Our Reference: **214001**

RE: RTS for SSD-23480429 at 253-267 Aldington Road Kemps Creek (Westgate)

Attachment 1 – Preliminary stormwater design review comments

Figure 6: Catchment extents under proposed conditions

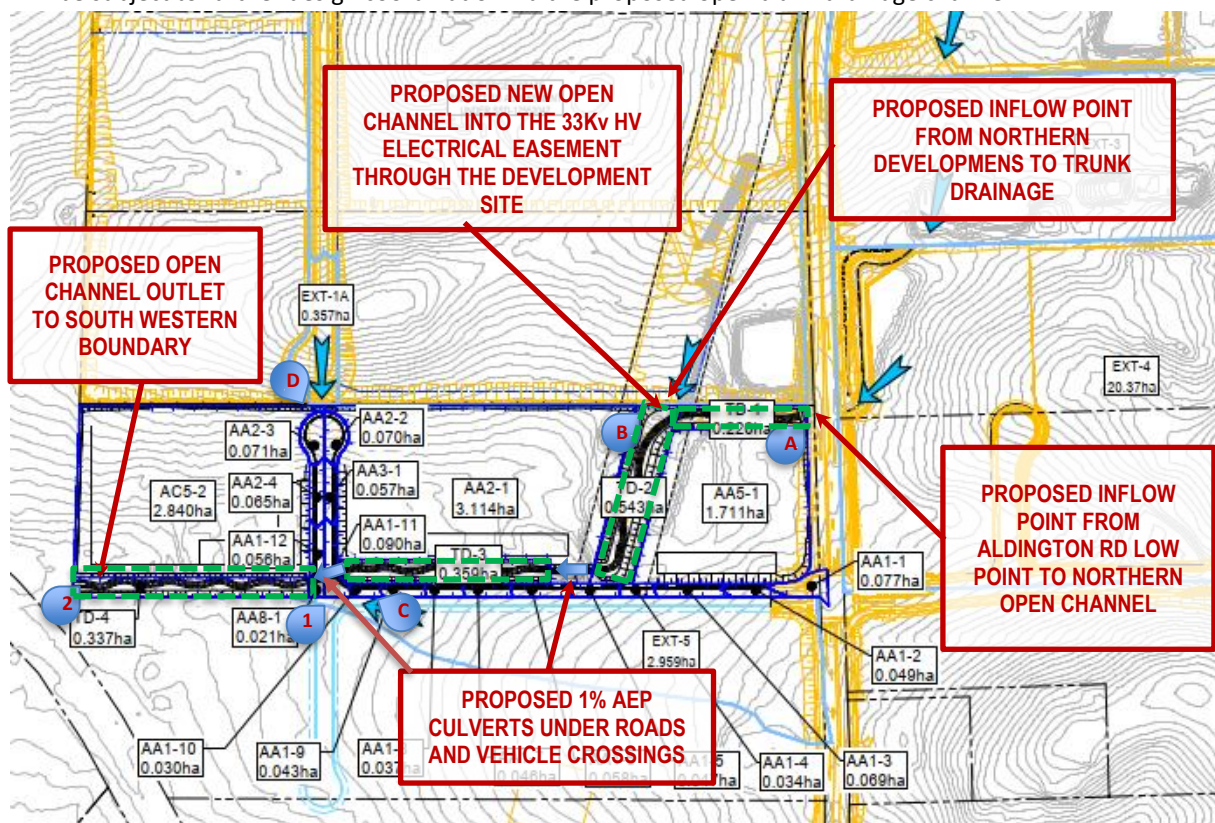
- d. Please provide post-development catchment map to confirm Trunk Drainage Channel Catchment.

Figure 8: Mamre Road Precinct Stormwater Scheme Plan (Dec 2022, Sydney Water)

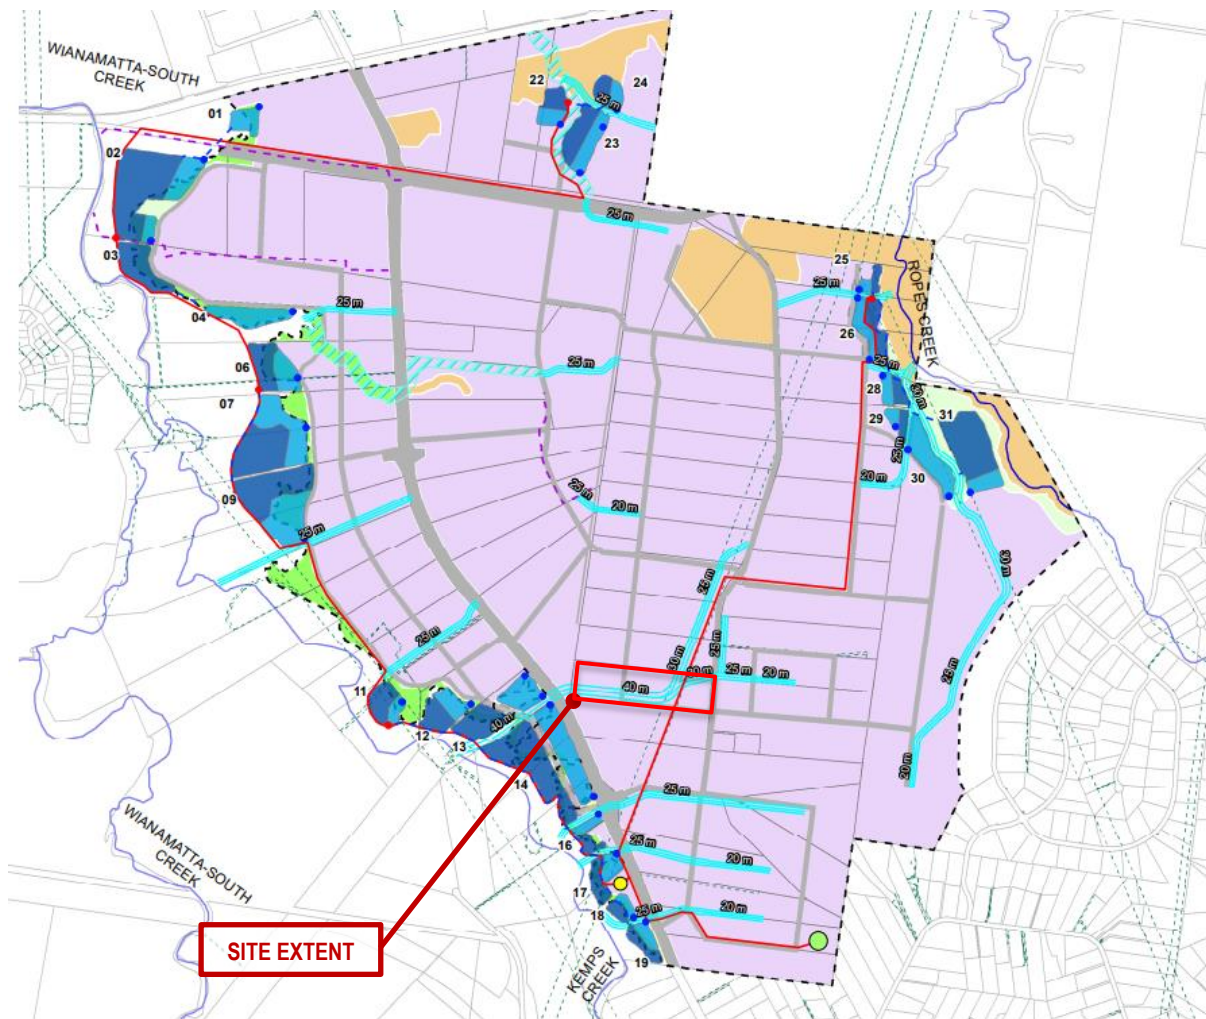
The proposed stormwater infrastructure **does not** align with the Mamre Road Precinct Integrated Stormwater Scheme Plan and the proponent has provided insufficient information, evidence, or justification for Sydney Water to accept or endorse the changes.

Sydney Water notes that the plans submitted request a reduction in the trunk drainage width and realignment of stormwater infrastructure that is substantially different to the December 2023 exhibited Mamre Road Stormwater Scheme Plan. Sydney Water recommends that the Department **defer** the approval of the SSDA application until these stormwater matters are addressed.

1.1. *Trunk drainage width change compared to scheme plan (40 to 20m)*

- a. Lack of information on flow velocity and volumes to determine if downsizing of channel is possible. There is no information provided regarding the incoming flows from the north (Fraser's) and east (east of Aldington Road). Note the channel from the north is not removed but is a hybrid channel and detention basin system, which will still need to provide trunk drainage properties.

The proposal incorporates naturalised trunk drainage channel alignments as shown on the scheme plan, however with the removal of the northern incoming channel, AT&L's modelling demonstrates that flows can be contained within a 20m channel instead of the 40m channel proposed in the Scheme Plan. The naturalised trunk drainage channel will discharge in a westerly direction at the south west boundary of the site.

Figure 9: Draft Typical Trunk Drainage Channel type 1 (Sydney Water 2023)

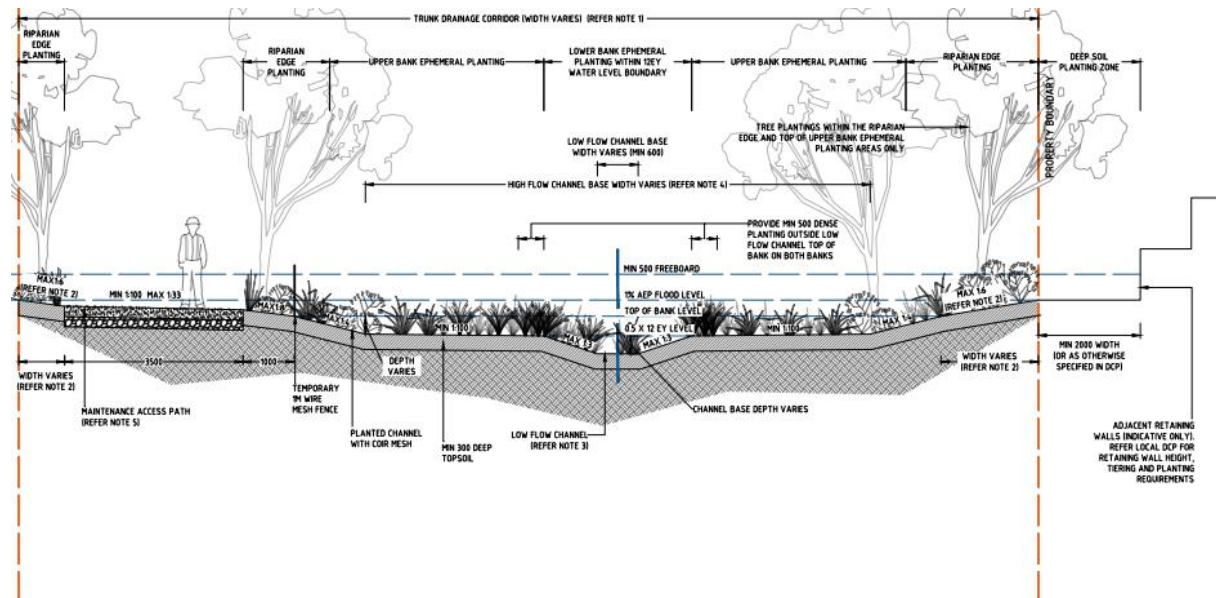
- a. Sydney Water is not satisfied with the current design with the 1% flows touching both the retaining walls. This will impact the structural integrity of the walls during high flow events which could impact the performance of the channels. The 1% flows will need to be contained within the naturalised channel bank and not against any retaining wall.

- g. There is a general lack of design and ideally more cross sections of the channel are required to be able to appropriately assess the design. In particular, regarding the western end of the channel, Sydney Water are uncertain as to why the channel batters have changed.

Figure 10: Stormwater Staging

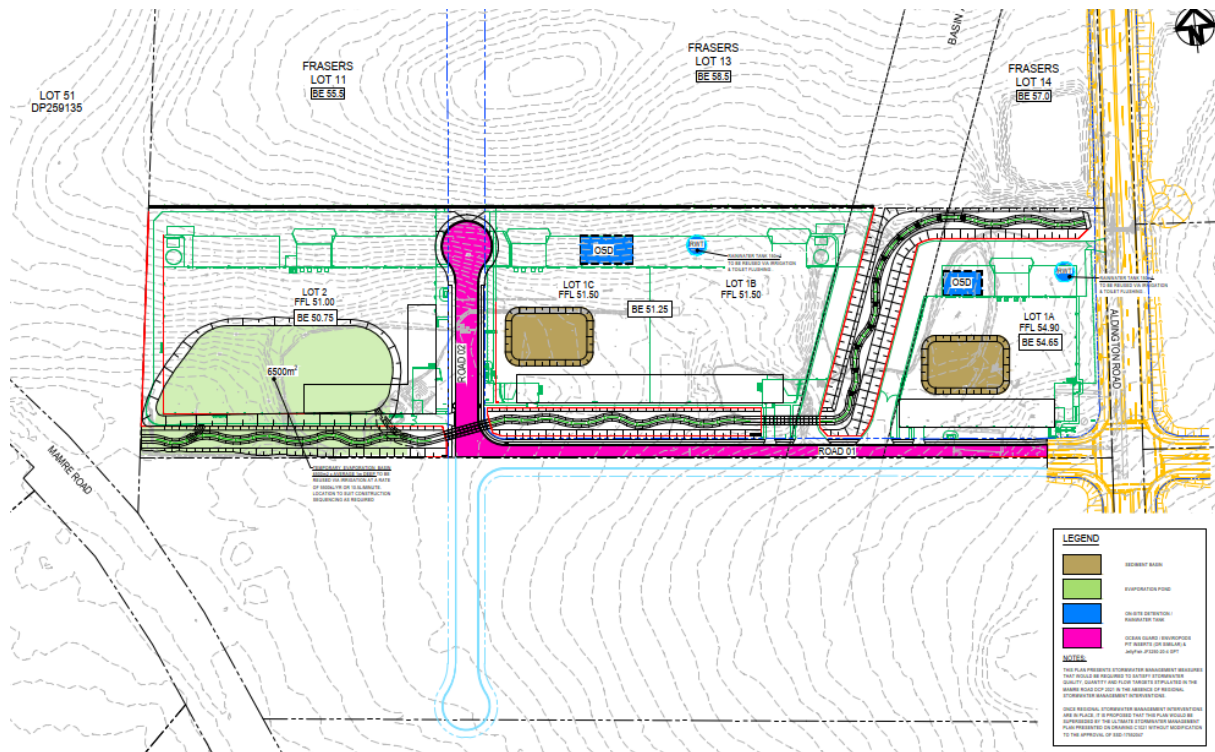
- The basin inlet and outlet design will need to be approved by Sydney Water. The design will need to show no impact on Trunk Drainage Channel performance and flooding.
- Note the Inlet and outlet of temporary detention basin in Stage 1 are to be commissioned and decommissioned at the developer's expense, and will not be reimbursed.
- Sydney Water will need more information regarding how the temporary basin in Stage 1 will function regarding the use of the channel flows, which includes external catchments/lots. Sydney Water has concerns about the sizing of the basin and the impact of uncontrolled quantity of stormwater on the Oceania lot.
